PUNCHLIST CONNECTIONS LLC
SUNSET VILLAGE FILING 4 - DRAINAGE
EL PASO COUNTY, COLORADO
CONSTRUCTION DRAWINGS
POND 2

PERMANENT CONTROL MEASURE
INFRASTRUCTURE DETAILS

FOREBAY SIZE TABLE

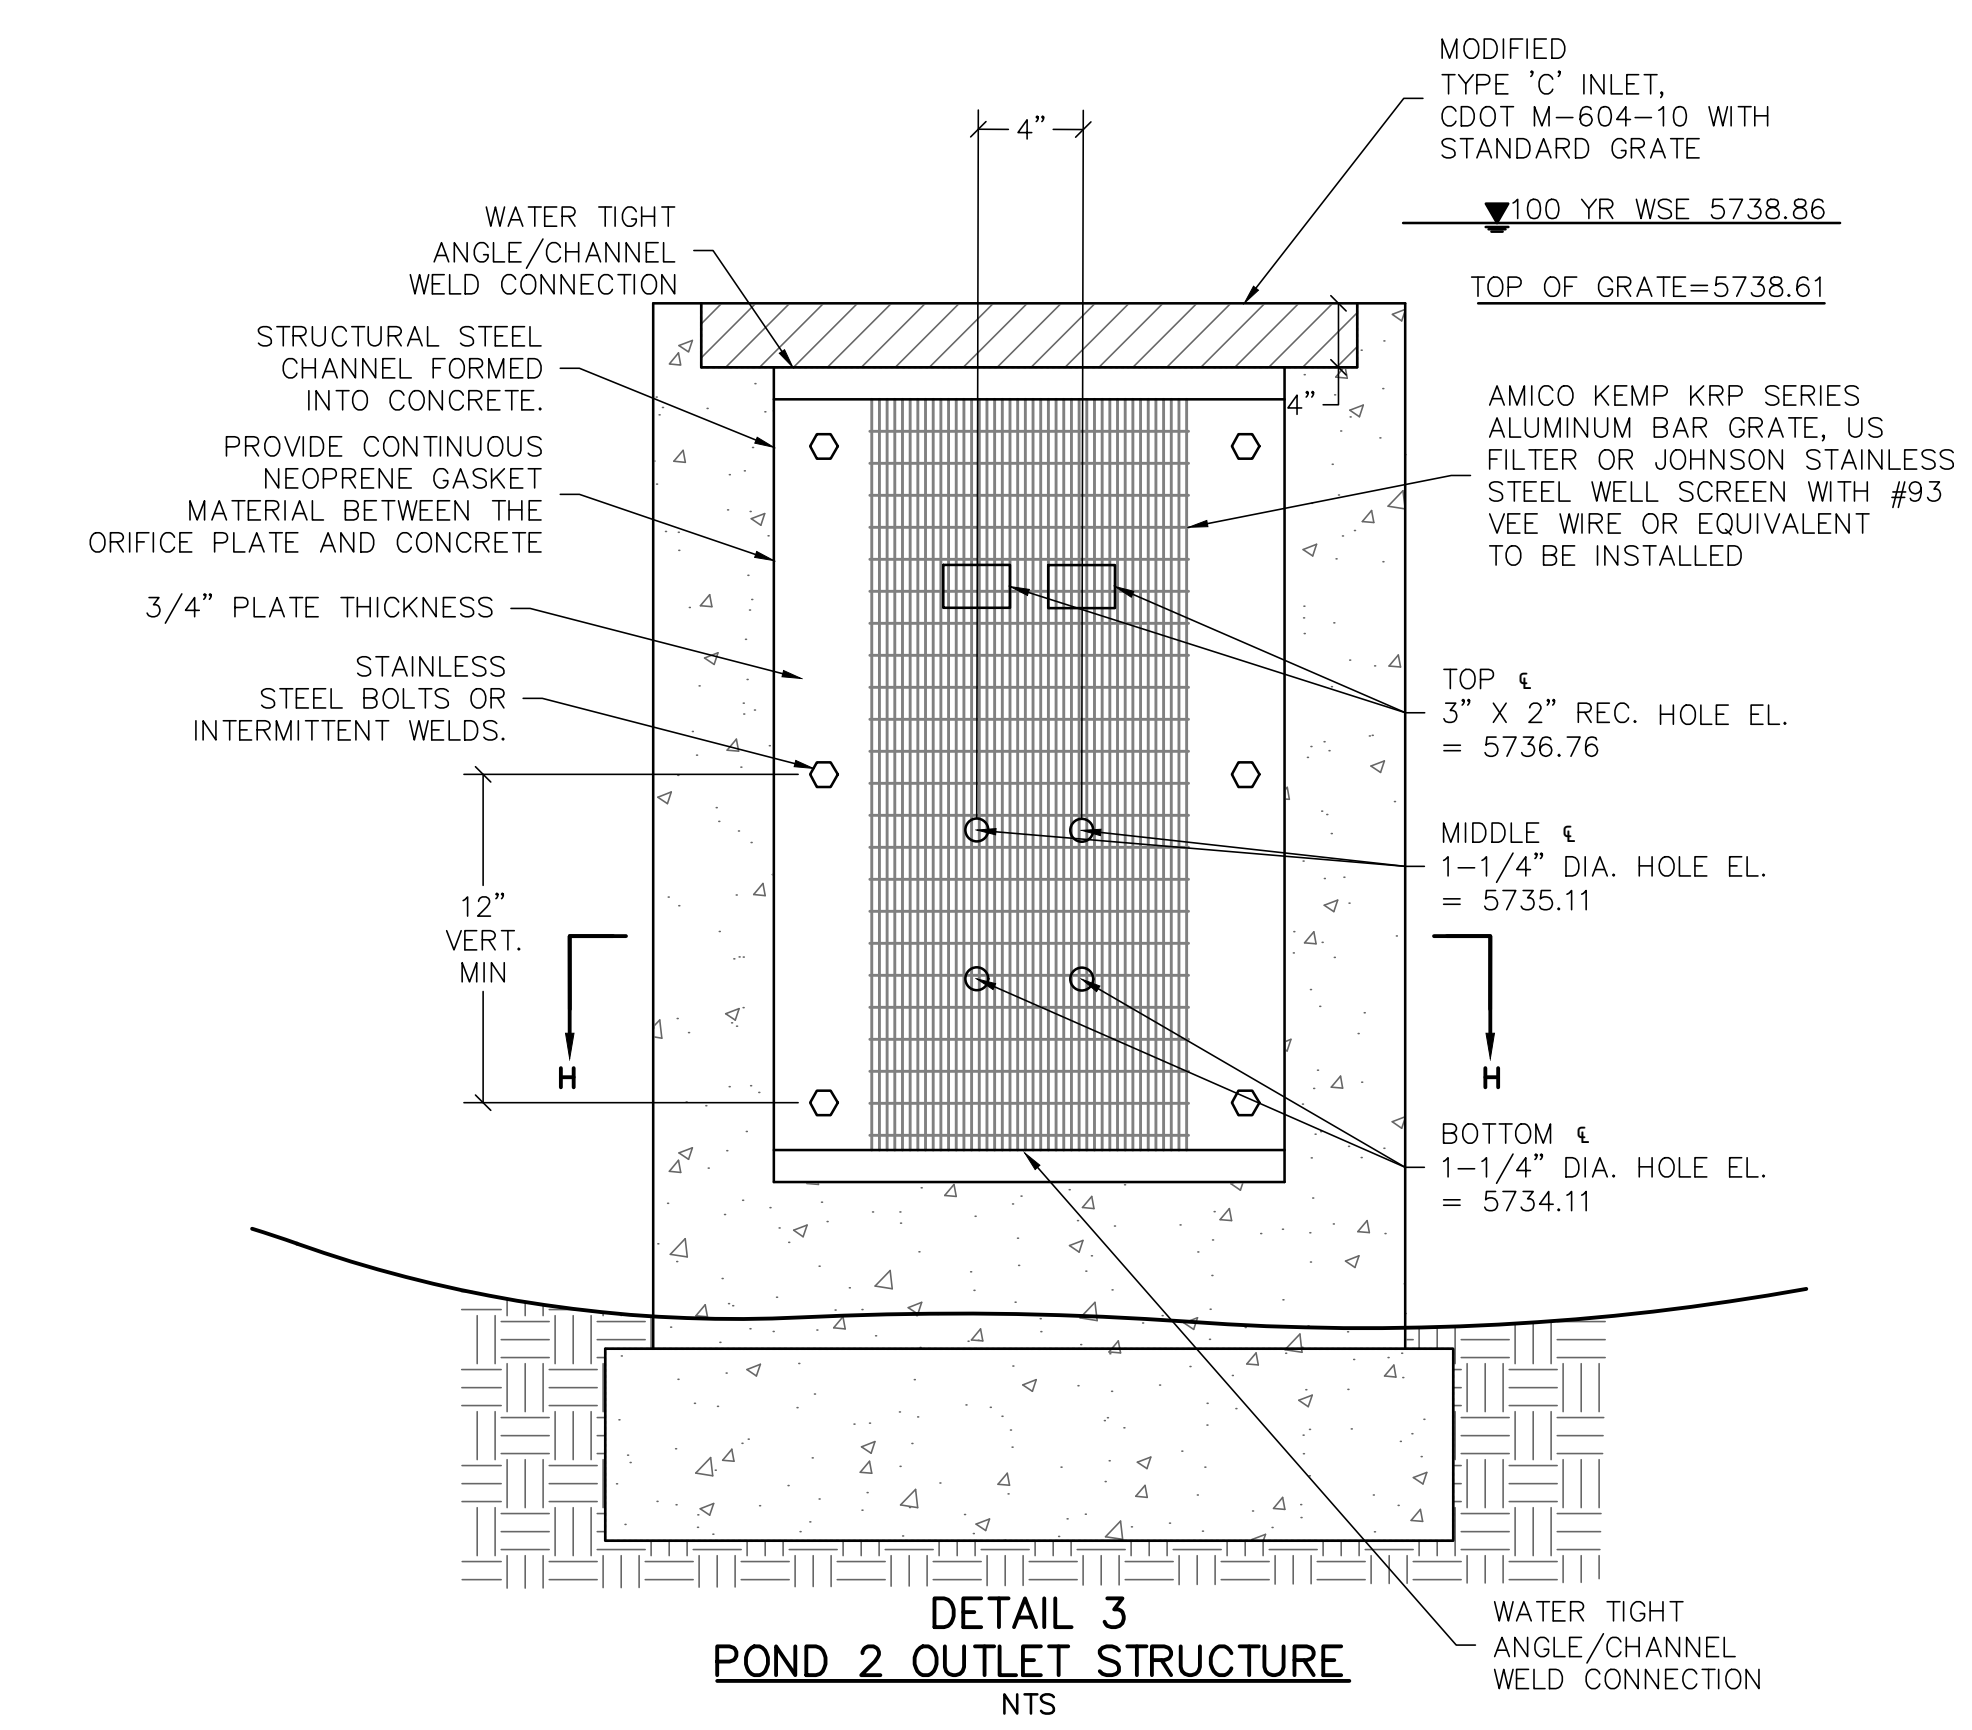
So you want soil riprap on one side of the cutoff wall and buried riprap on the other side? Please confirm, 99% of contractors will miss this nuance, better to just make them the same. If you revise one of these callouts, be sure to check/revise all other plans/details to make sure they are consistent with your choice.

Agreed, we have revised to remain consistent on both sides.
